COMMUNITY DEVELOPMENT DEPARTMENT  
80 Columbia Avenue ♦ Marysville, WA 98270  
(360) 363-8100 ♦ (360) 651-5099 FAX

Re: Marysville Corporate Center – *Technical Review 1*  
PA 22004

RE: Marysville Corporate Center, File# PA22-004  
Binding Site Plan  
15908 47<sup>th</sup> Ave., Multiple Parcels

**PARKING COMPLIANCE – BLDG 207**

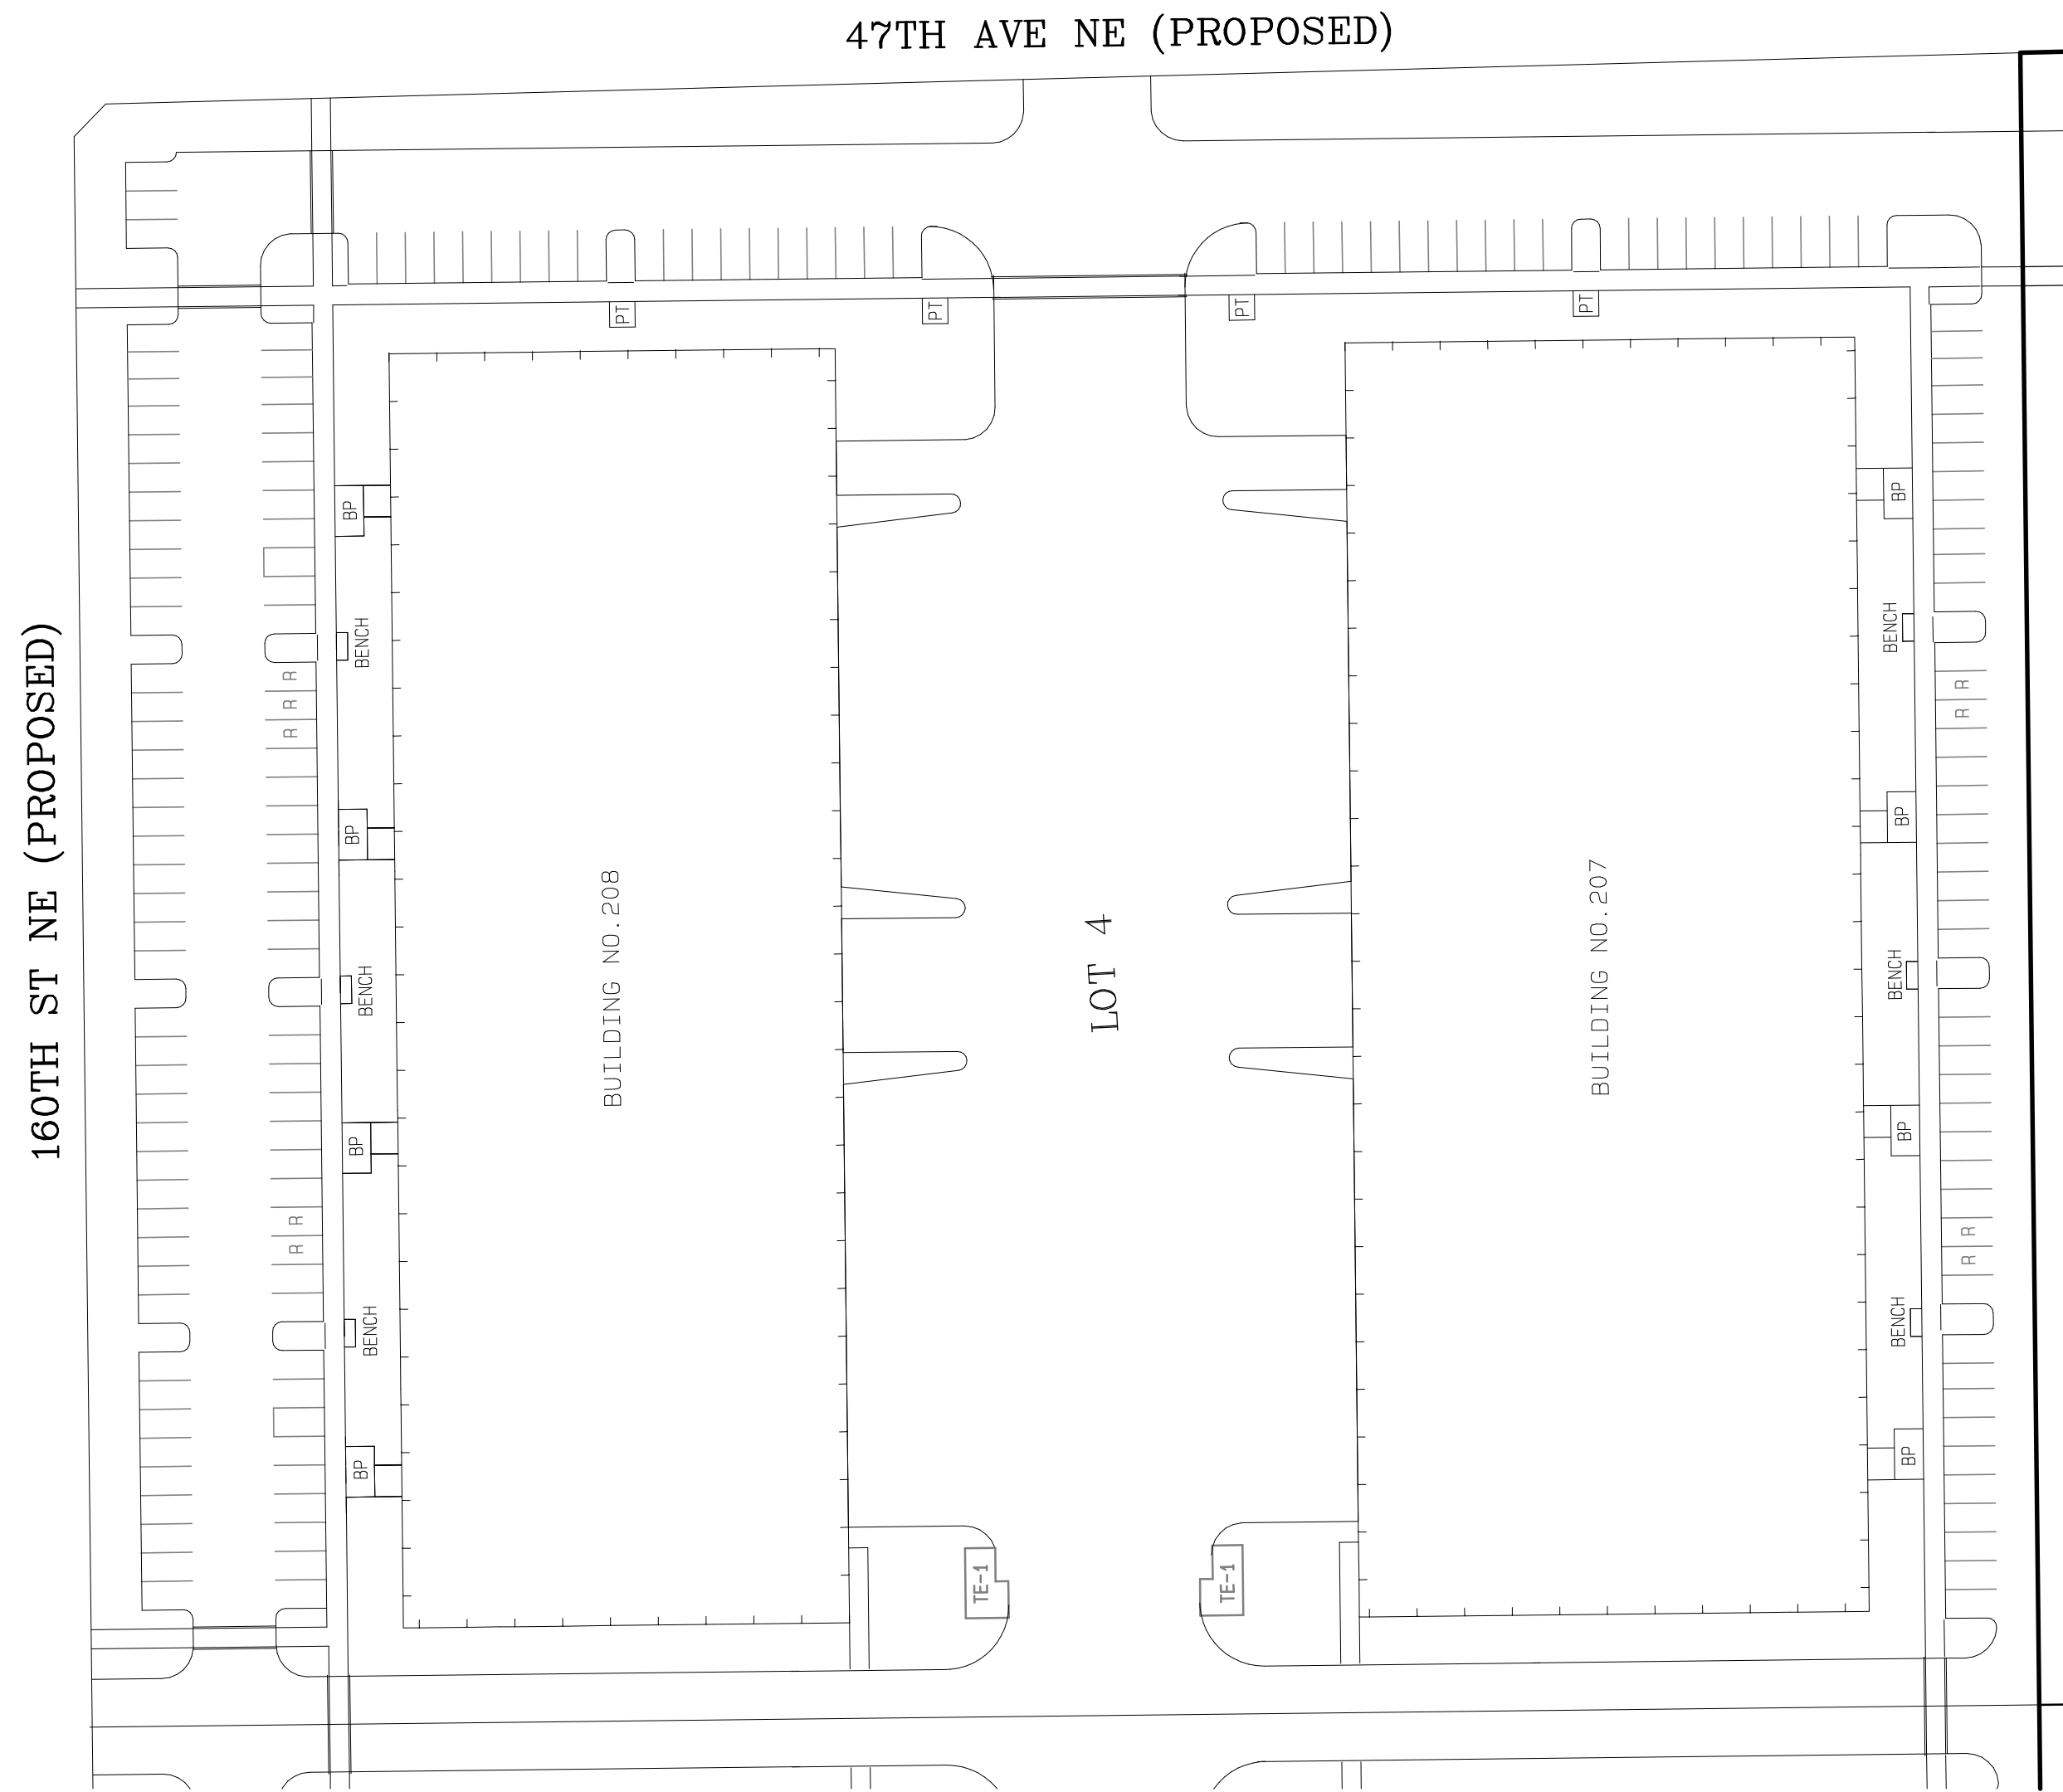
- g. Provide a "ZONING COMPLIANCE" section demonstrating compliance with the LI bulk & dimensional standards outlined in [MMC 22C.020.080\(2\)](#).
- h. Provide a "PARKING COMPLIANCE" section demonstrating compliance with:

- i. Minimum required parking spaces outlined in [MMC 22C.130.030](#) Table 1.
  - ii. Provide carpool parking locations and calculations in accordance with [MMC 22C.130.030\(3\)](#).

- iv. Minimum parking space and aisle dimensions outlined in [MMC 22C.130.050](#) Table 2.
  - v. Depict actual turning radii proposed, in accordance with [MMC 22C.130.050\(5\)\(b\)\(ii\)](#).

## PROPOSED AUTO-TURN & TURNING RADII PLAN

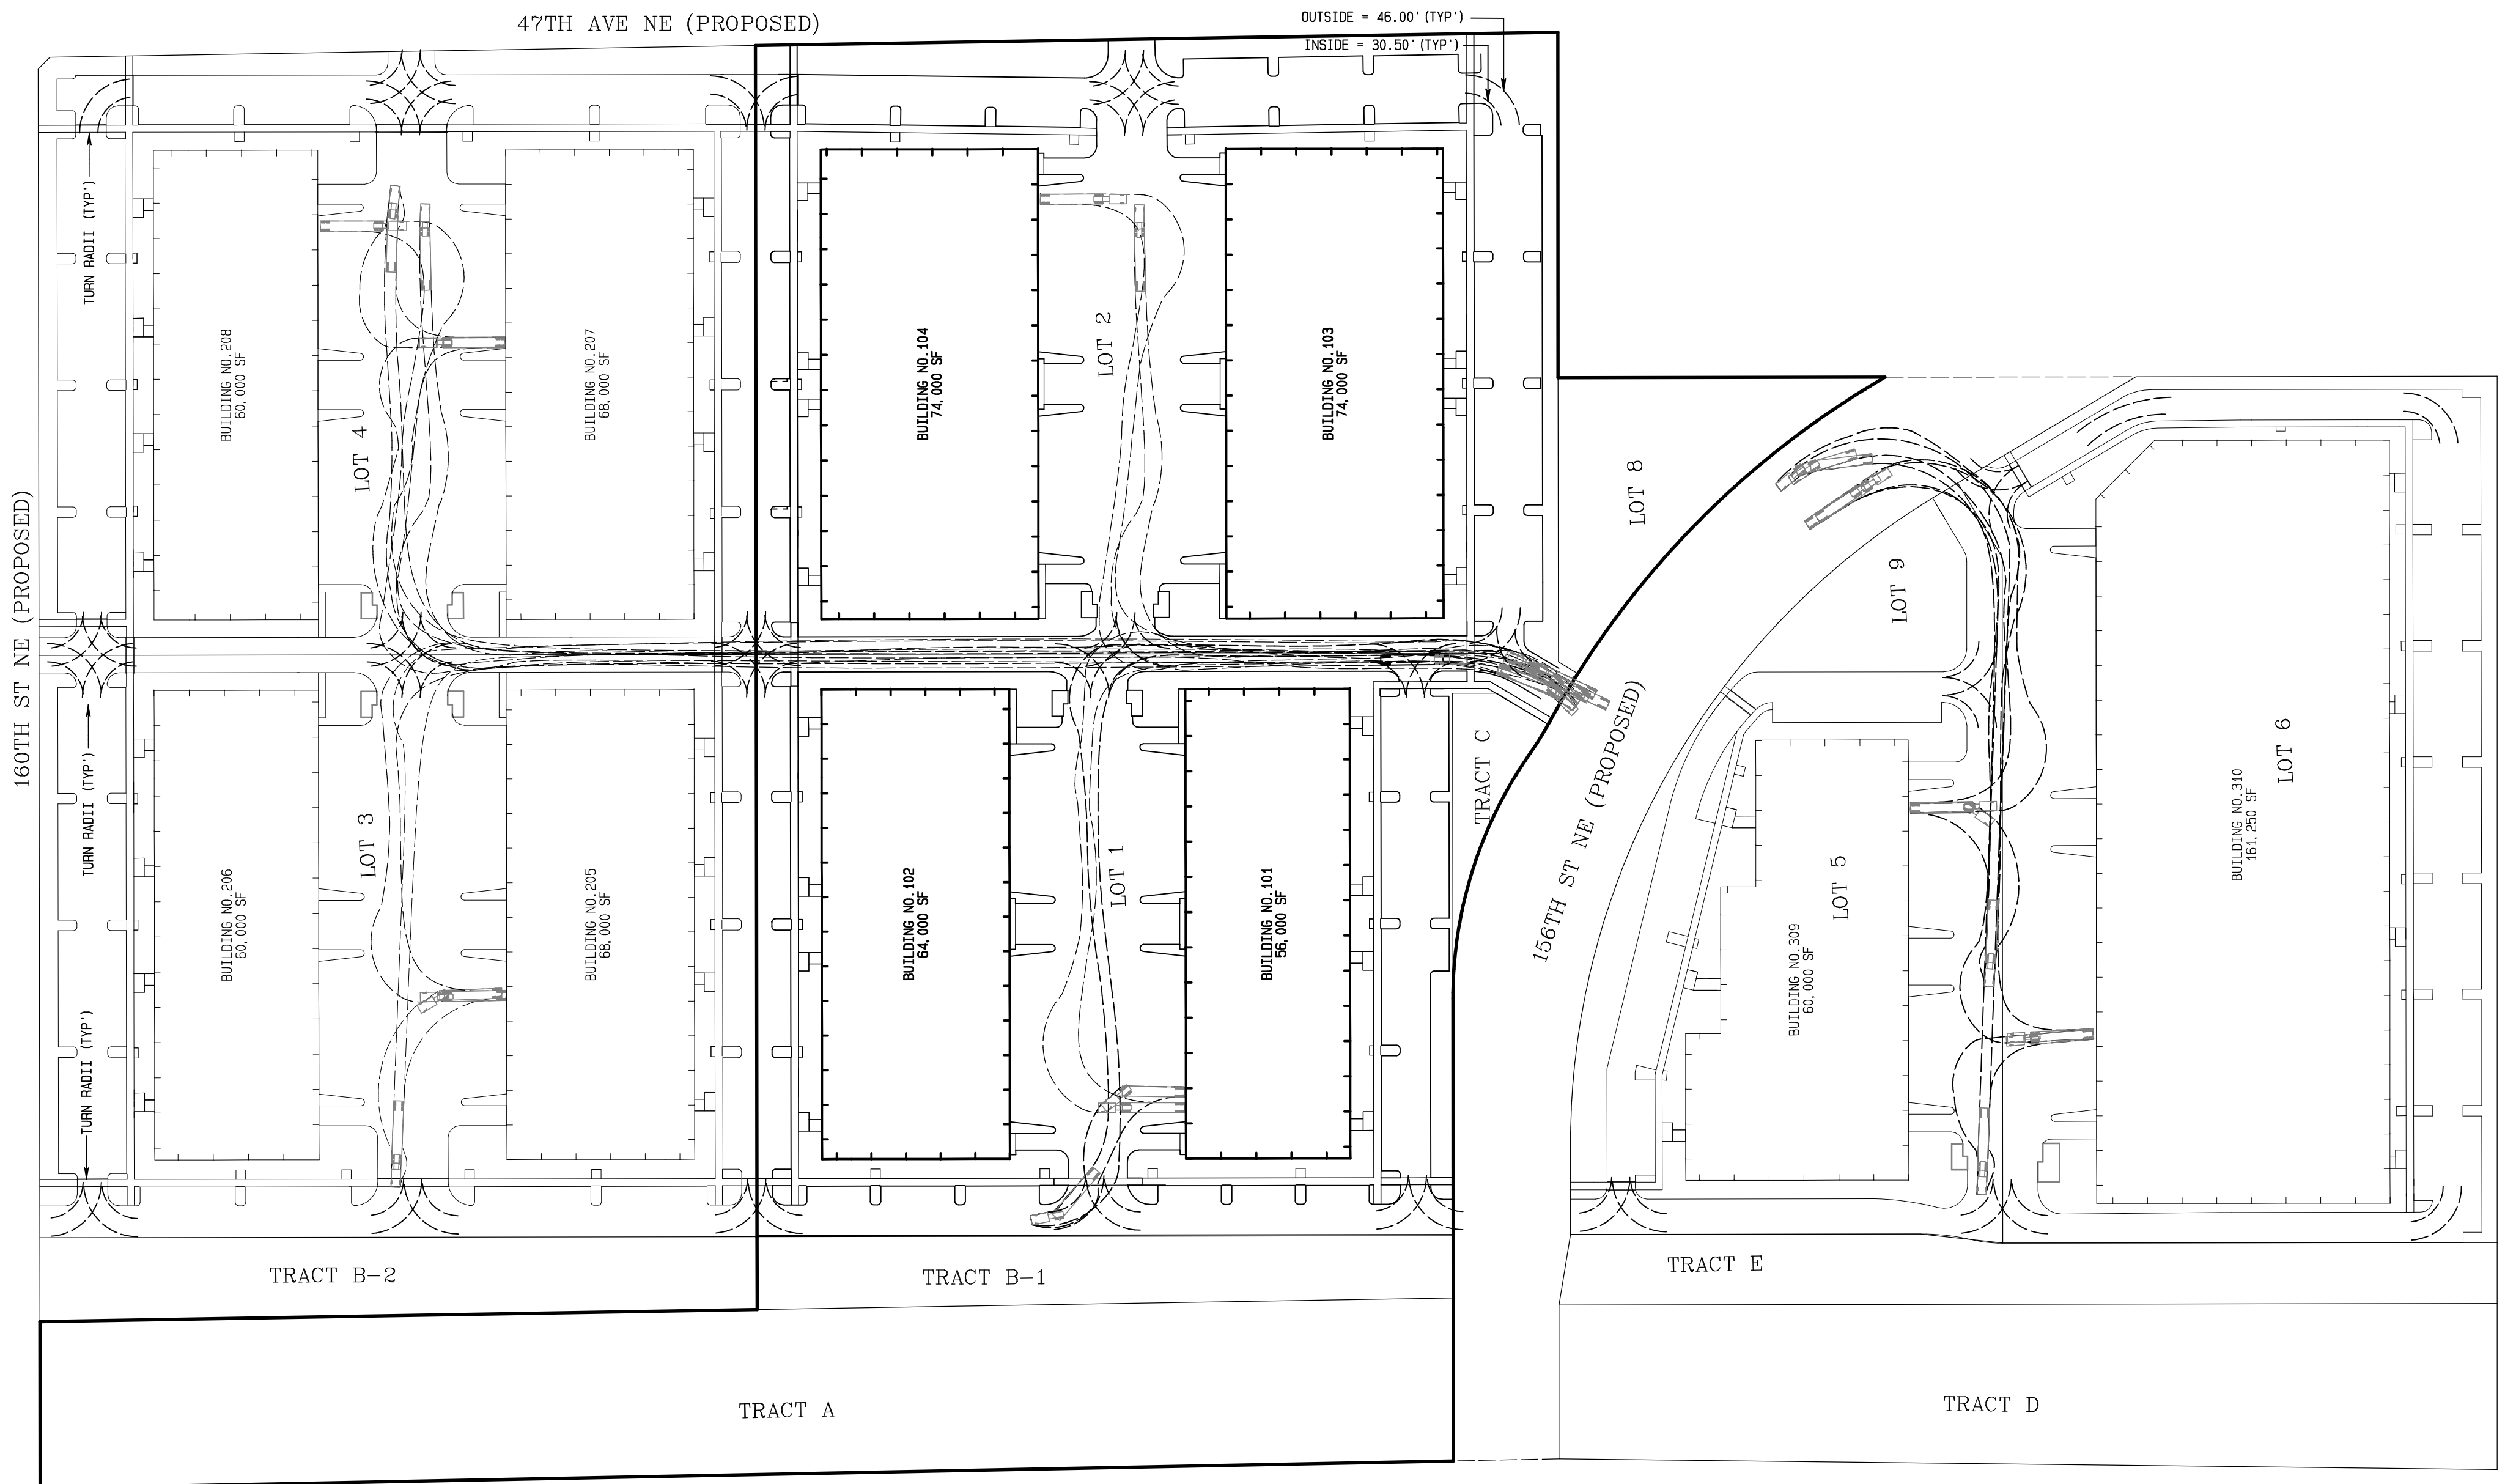
- vi. Provide an auto-turn exhibit showing that the largest trucks navigating through the site will not damage any vertical curbs and landscape islands.
